Demolition of existing house with erection of 2 storey building comprising of 8No.
residential 2 bedroom flats & associated external works
1 Sea Drive Ferring

Thank you for your internet representation made on 28th June 2017 which has been recorded as **'an objection'** with the comments as follows:

BASEMENT FLOOR PLAN

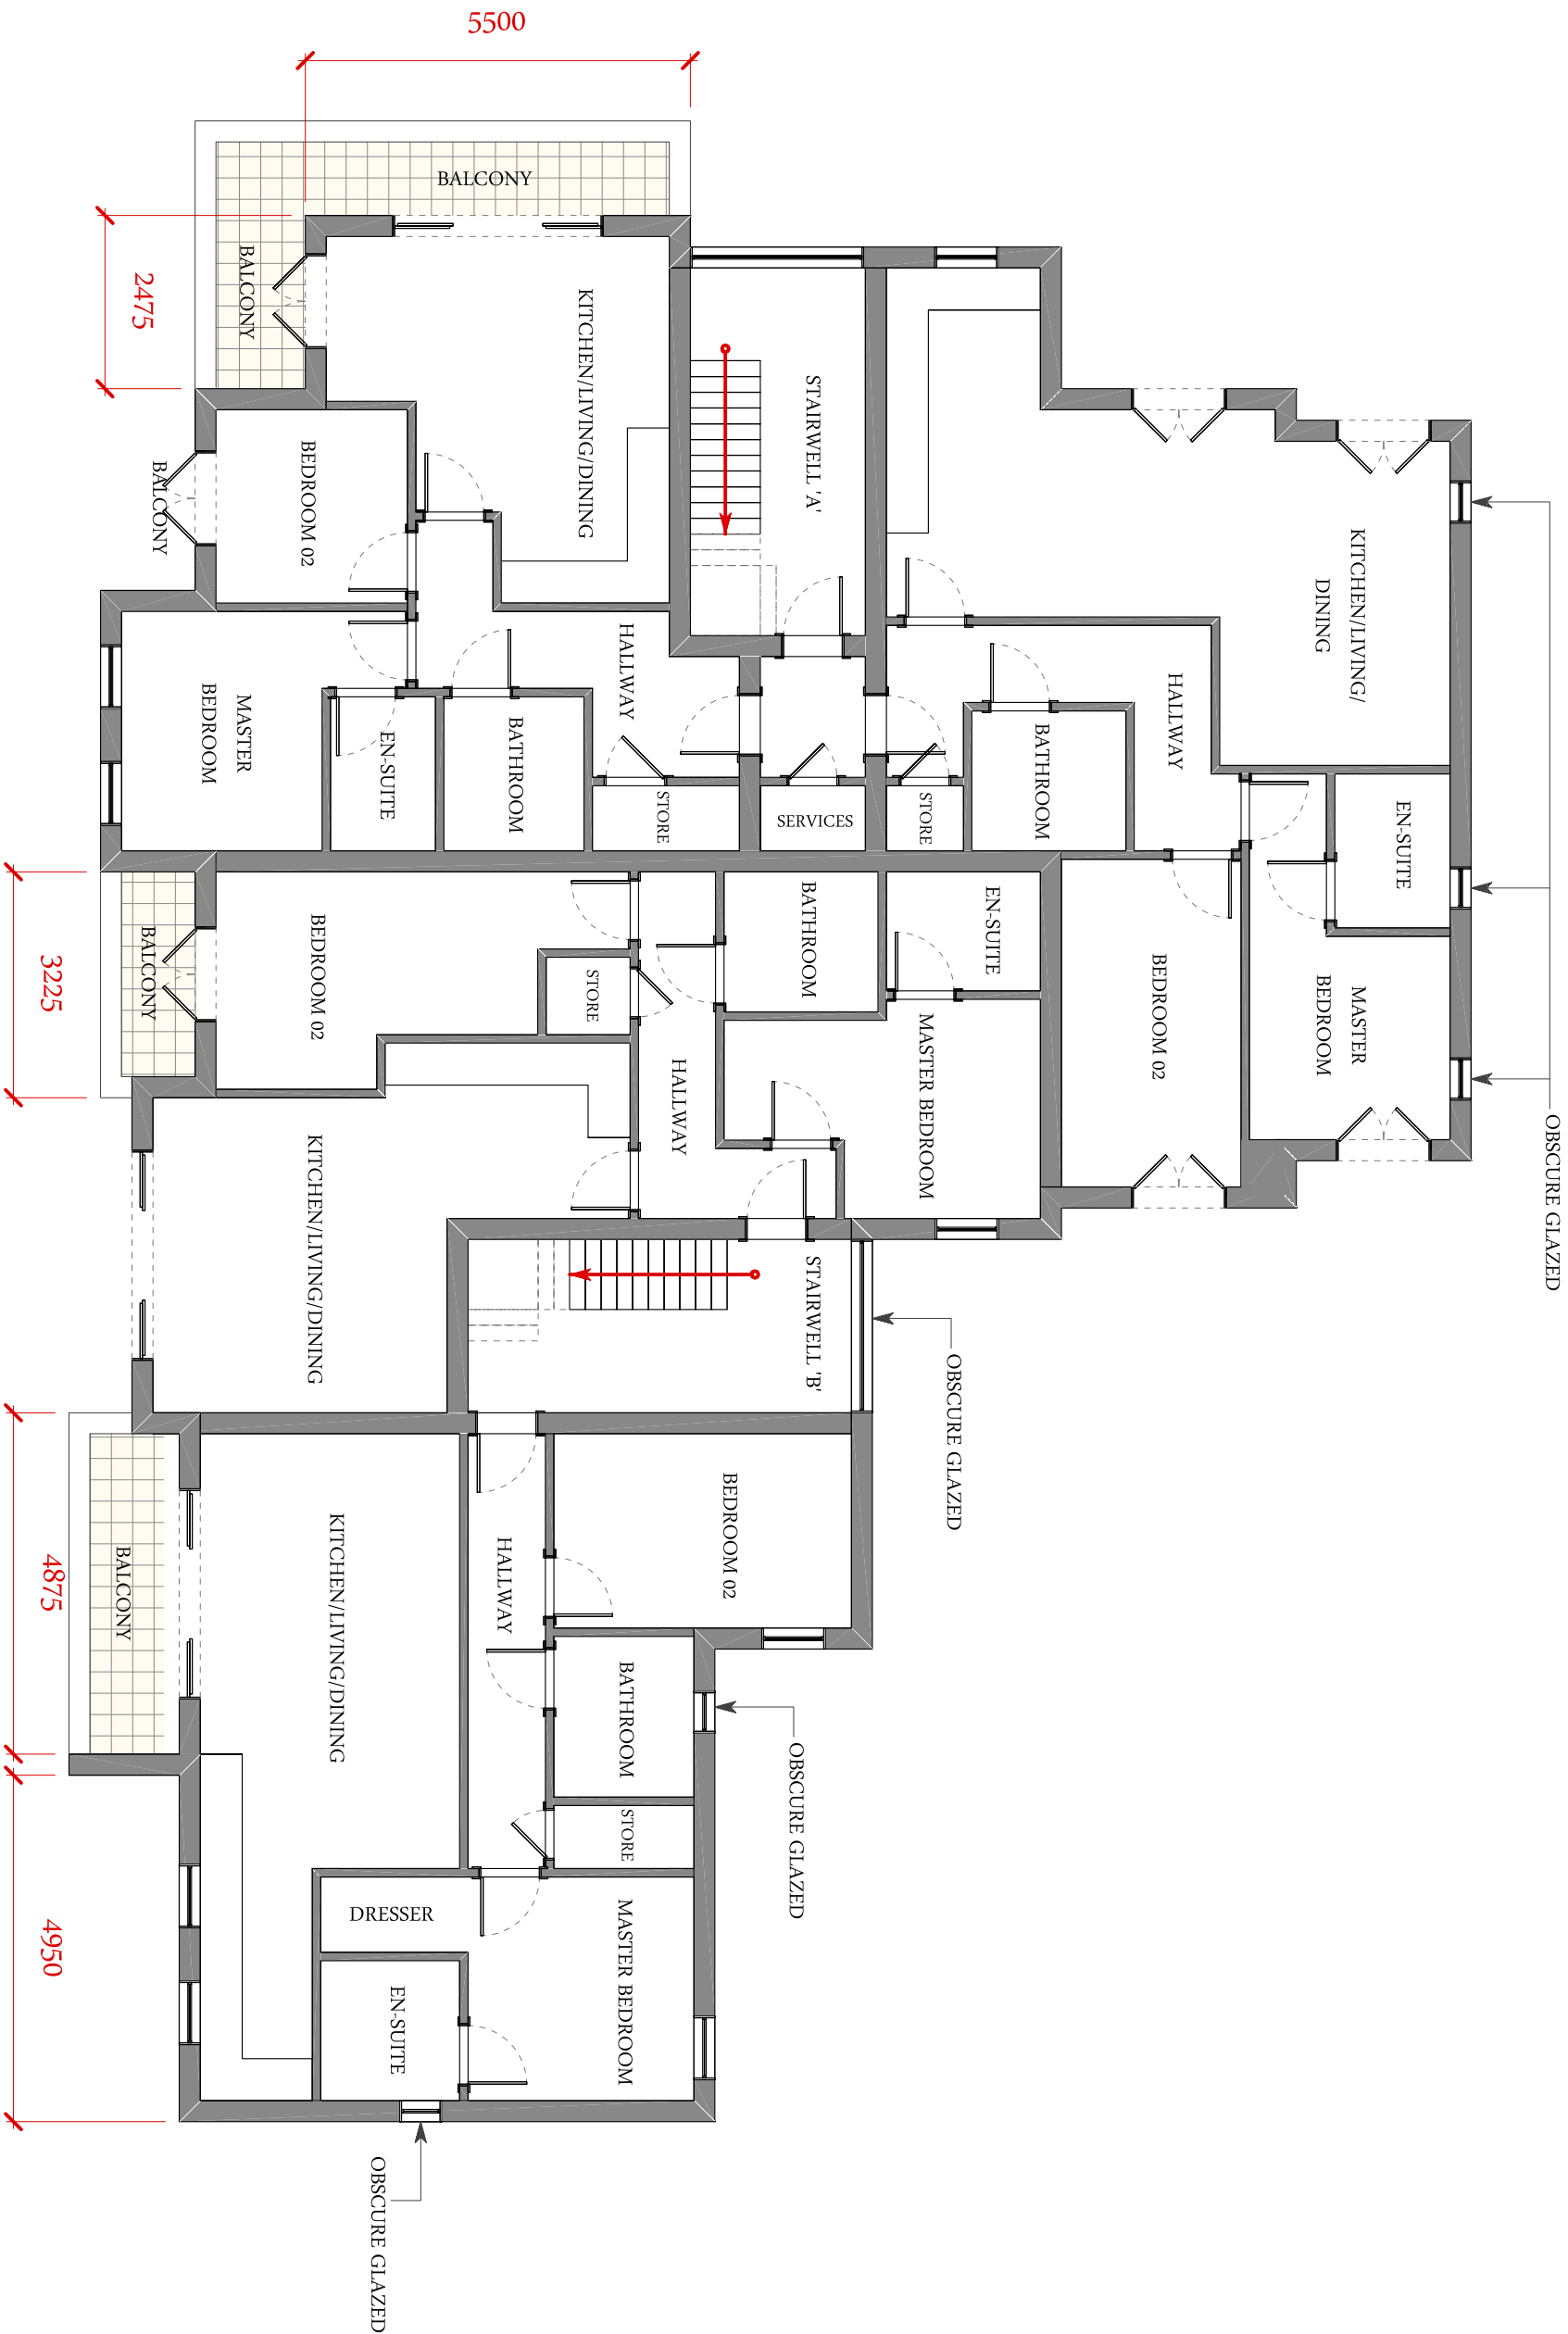
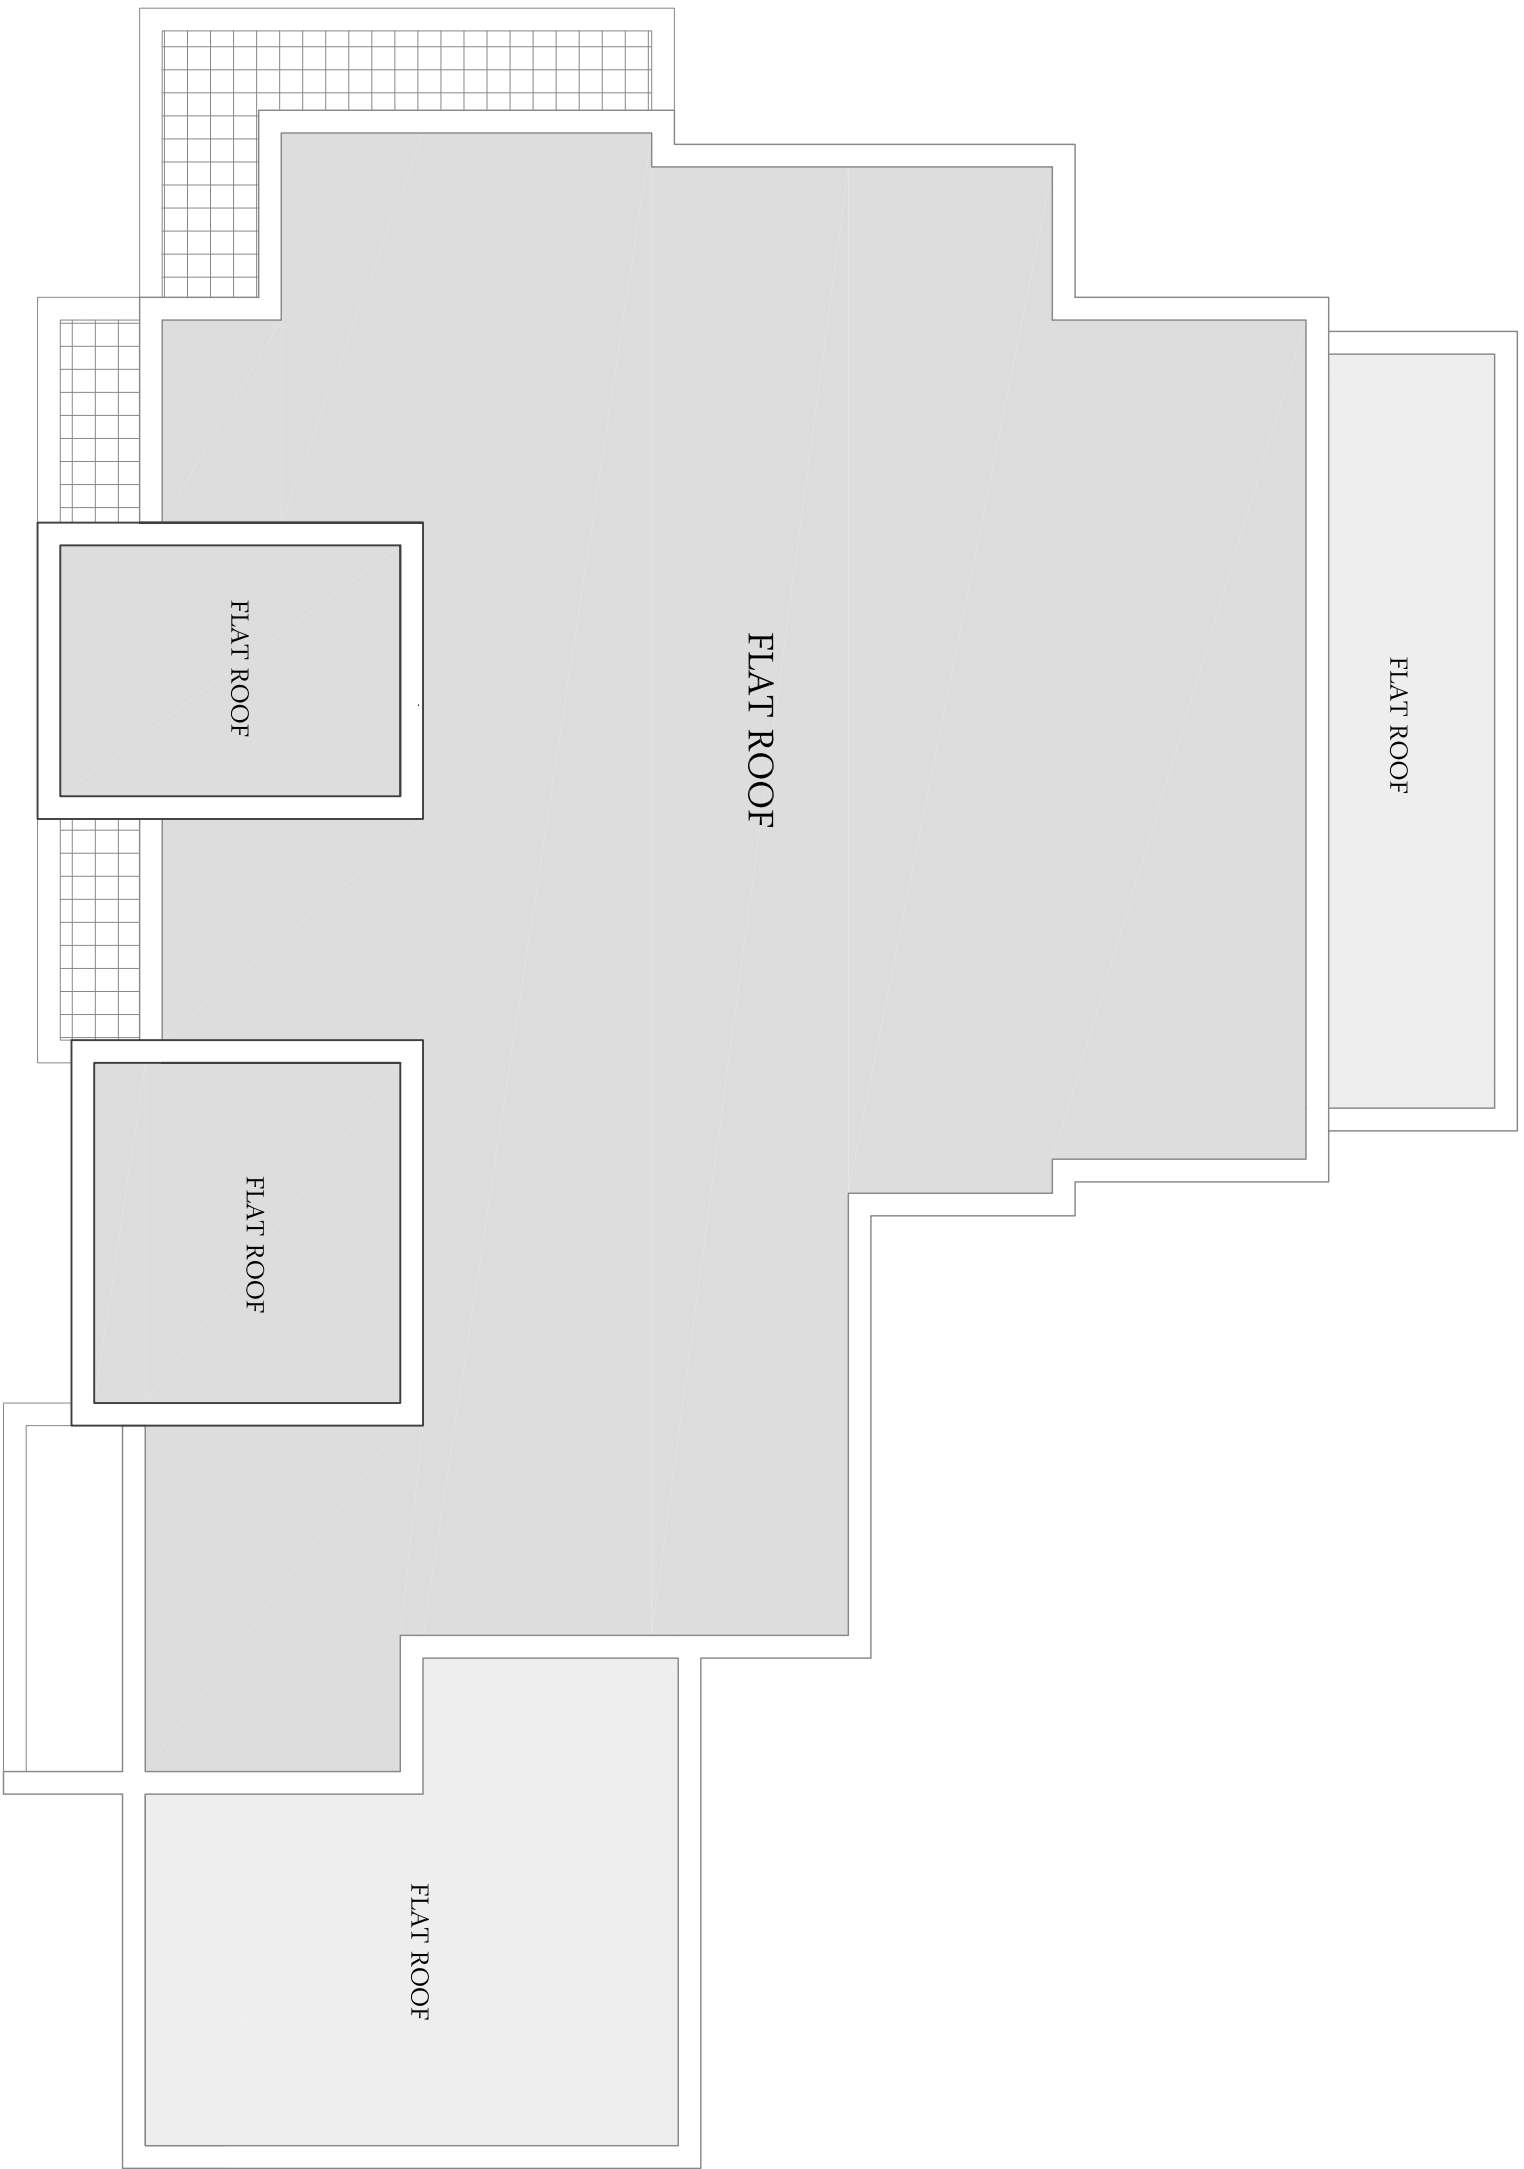
The underground parking shown in the latest amended plan is impracticable. If one compares it to the earlier plan submitted for the Tracked Path, one can see that the 9 parking spaces have been narrowed to the point where the car illustrated in the Tracked Path plan would not be able to open its doors if the neighbouring space was occupied. And although the Tracked Path shown earlier was geometrically possible it would have taken a skilful driver and a smallish car to achieve it in practice. With narrower spaces and more cars in the basement it now looks impossible. I trust the Council will re-submit this plan to WSCC and ask for further comments.
